Application no: H09-0361-10

Description: Conversion, alteration and extension to former public house into 7 self-contained flats with associated parking and amenity land

Location: 12 Station Street
Holbeach
Spalding
Lincs
PE12 7LF
PE12 7LF

Amendment: Minor amendments to elevations (dwg. no. 0911/05A)

STREET ELEVATION

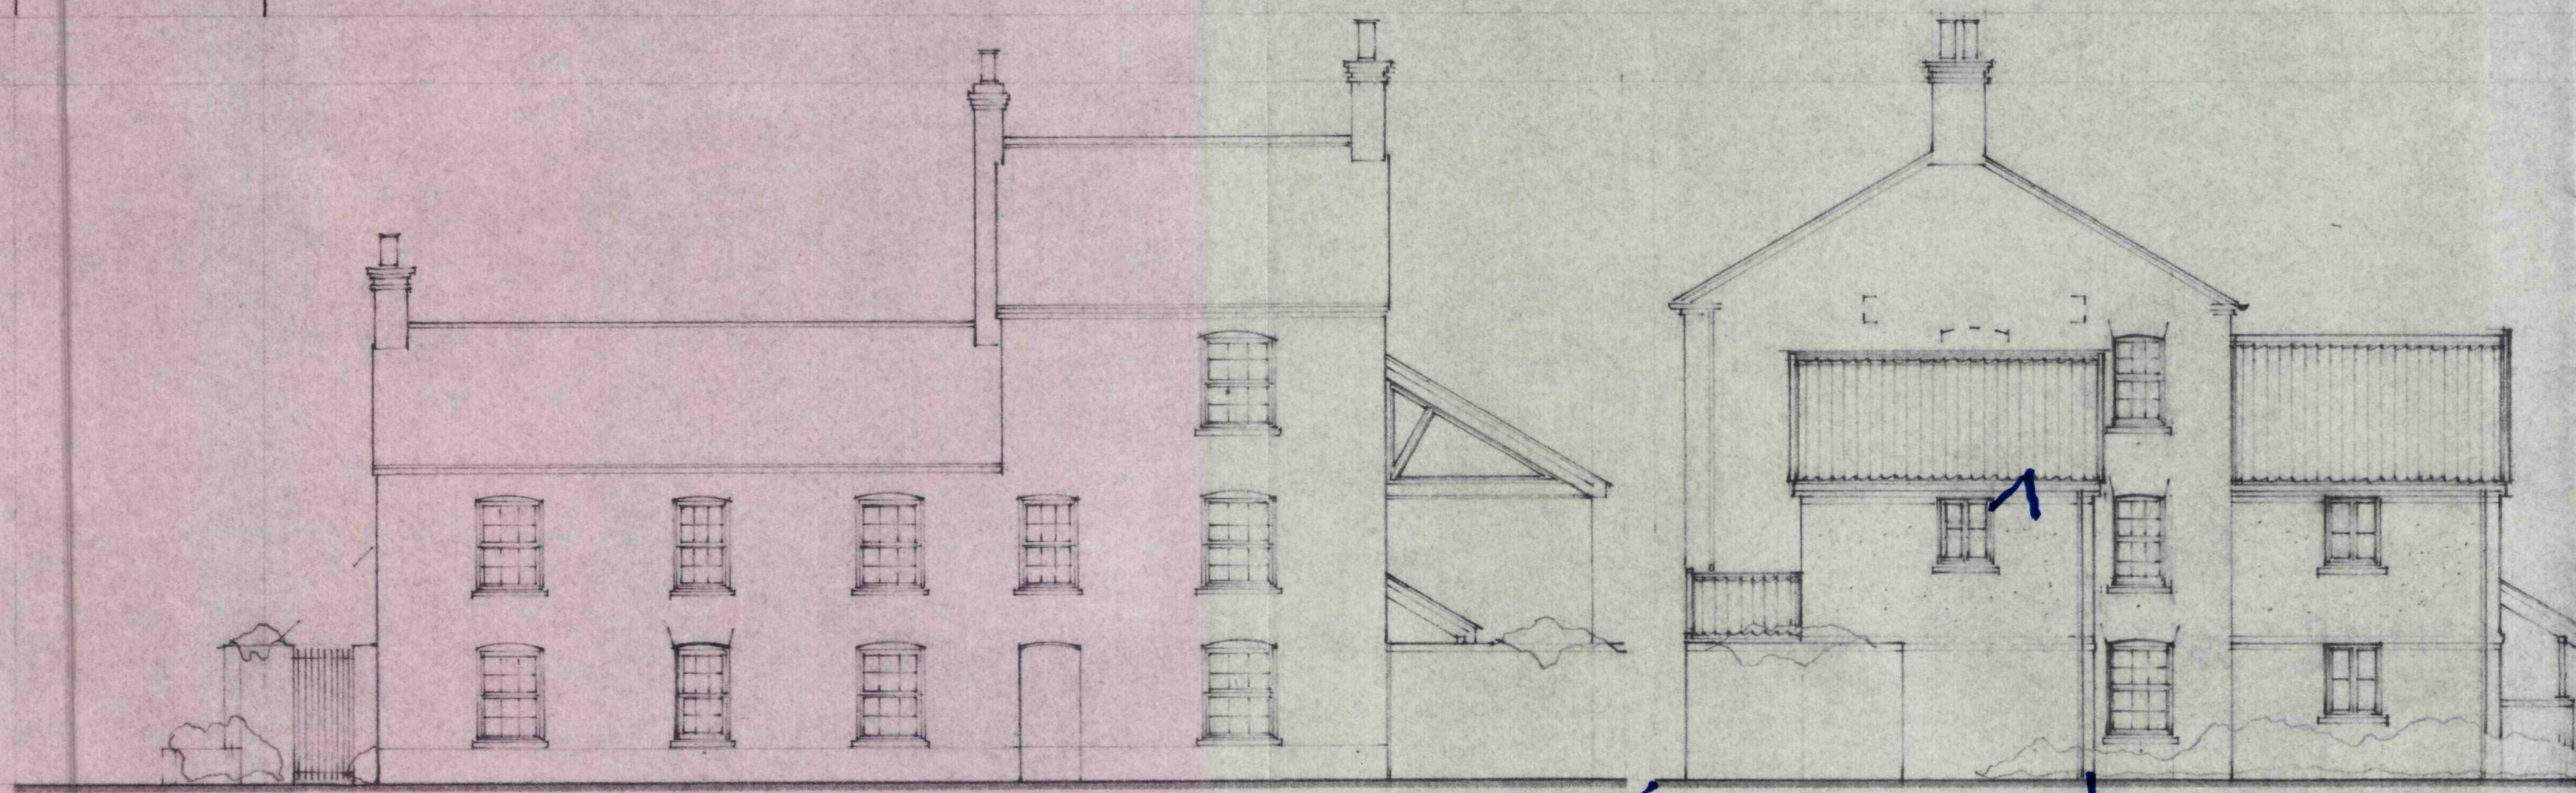
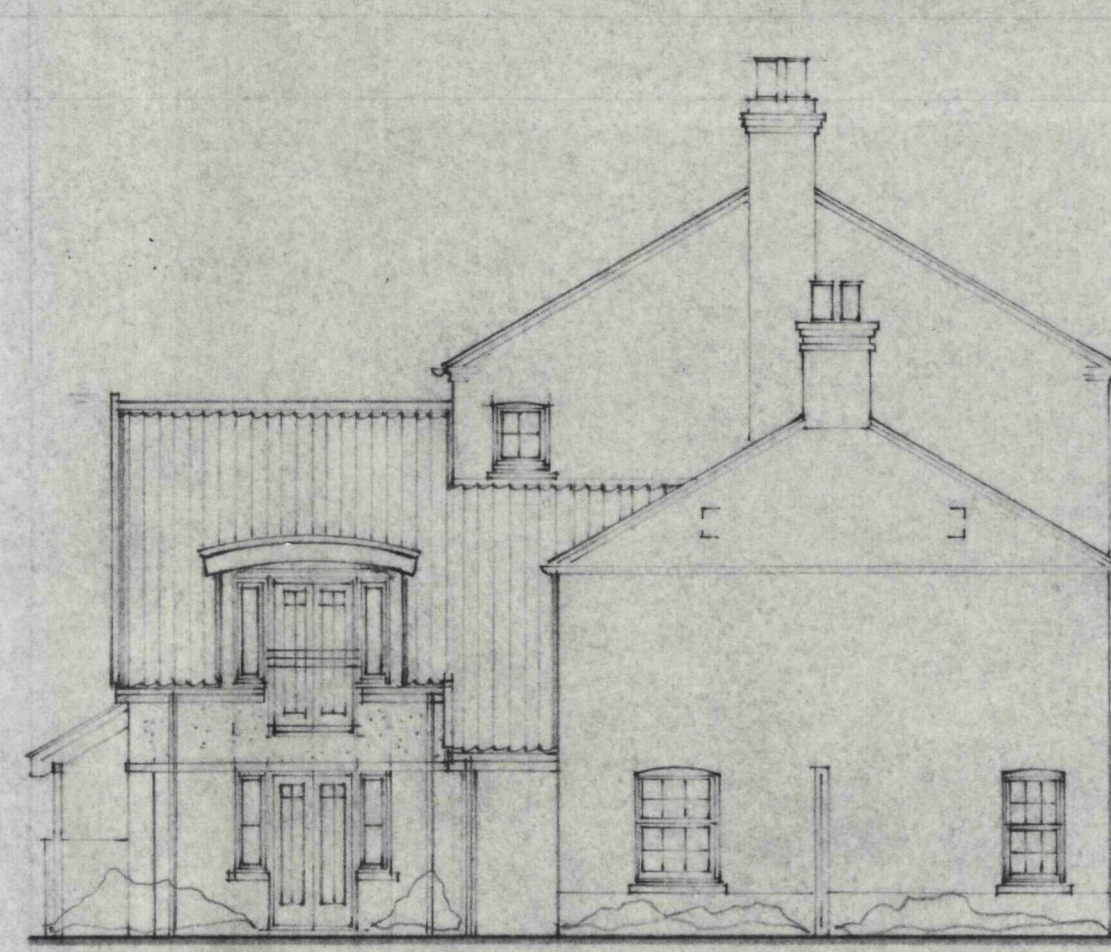
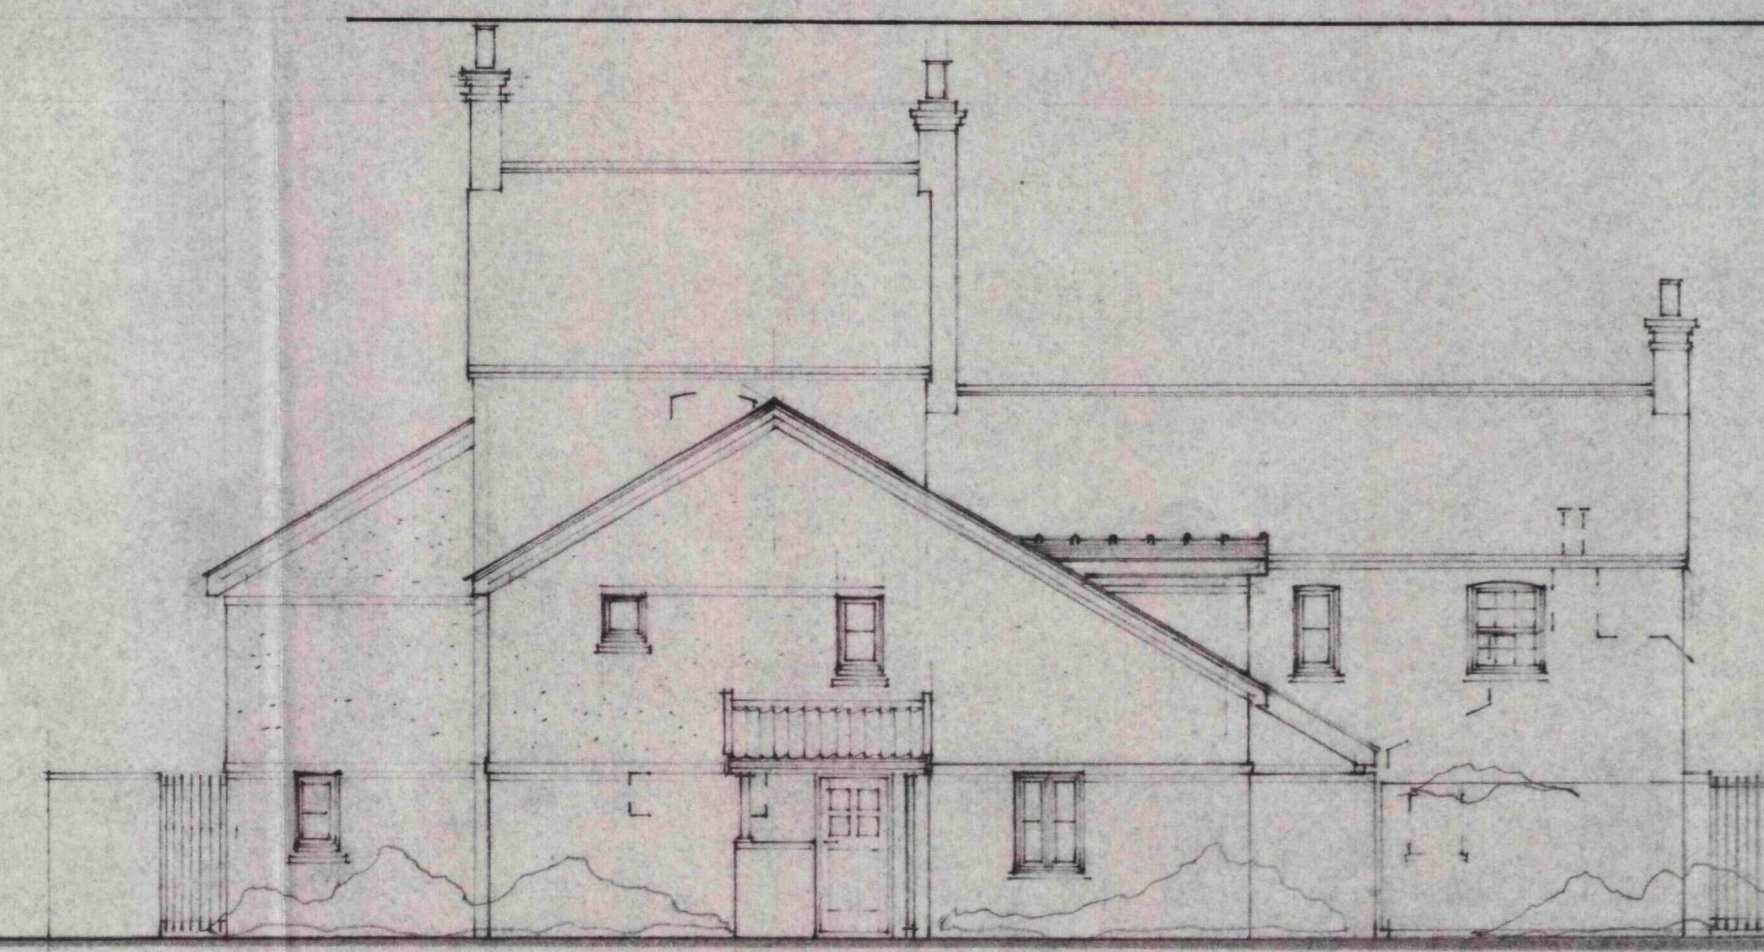
4. I still consider that the side extension should closely match the main building in terms of materials and detailing. In my opinion, the whole of this element should be rendered with a pantile roof, brick detailing at eaves level, no bargeboards and a Georgian style sash window on the side elevation. Also, I am not too keen on the semi-circular wall on the eastern side of the access, which should be revised to match the opposite side.

5. No objections are raised to deletion of the triangular glazed panel and addition of a roof light.

rear would give rise to a number of impracticalities/problems. I am therefore prepared to compromise in respect of this element, subject to the eaves and ridge details of the rear extension matching that of the existing building, as confirmed in your email.

7. I really need to know whether the existing windows on the front elevation are going to be replaced? The appearance of the building would be much improved if new timber Georgian sash windows were inserted. No objections are raised to balanced casement style windows with glazing bars on the rear extension, given that this element would read separately to the main building.

In respect of the detail, the site is in a prominent location within the town, close to the conservation area. As a result, a number of design changes are considered necessary for the scheme to be acceptable. In terms of materials, the exterior paintwork should preferably be stripped on the existing building and the new extensions constructed in brickwork to match. If this is not possible, all the new extensions should be rendered in their entirety to match the existing building.

Concerning design alterations, the side kitchen/bedroom extension should have a plain elevation facing the road (ie, the timber detailing should be removed). The eaves and verges should match the existing building and a window could be introduced at first floor level to help break up the expanse. All new windows should be of similar style to the original windows on the building (ie, Georgian with segmental arch).

In respect of the new extension at the rear, the roofline is unsympathetic. This should be revised to a double gabled element, consisting of two ridges running perpendicular to the road. Eaves, verge, window detail, etc should again match that of the original building.

Regarding item 4, I remain quite strong in my views for the introduction of facing brickwork at ground floor and render above, with matching eaves and verge detailing. My reasons are as previously stated, that the scale and proportion of this extension is in keeping with the initial "makeover" and extension to the flat-roof structure, and lead the eye into, and read in conjunction with the future re-development of the rear of the site. The only other option is to have painted

Regarding the semi-circular boundary wall, as previously stated, this has appeared on both preliminary sketch schemes, and is a very deliberate use of natural geometry to continue the opening into the site as a private courtyard entry to this dwelling. I have carefully considered the proportional balance, and as stated above, it makes sound sense to continue the facing brickwork to the ground floor level. You requested the removal of paint to reveal the original red facing brickwork, and I feel that this composition re-introduces that material to both gables with the new external walls and extension. The only other solution would be to change to a buff facing brick, which I don't think either of us would be happy with, and would be a wrong choice for this site.

5. As discussed, what you've read as a timber detail on the front gable to the extension is actually a triangular glazed panel above eaves height. You stated that you are happy for this detail to be transferred to the rear gable and swapping the proposed wall finishes. On reflection, this detail works best with a bargeboard detail. Therefore, rather than have an imbalanced detail, I am omitting this element and adding a Velux roof light to give natural light within the open ceiling area below. I have amended this on the drawing and attach scanned copies.

possibilities to the rear of the site. I am happy that the eaves and ridge details can match that of the existing.
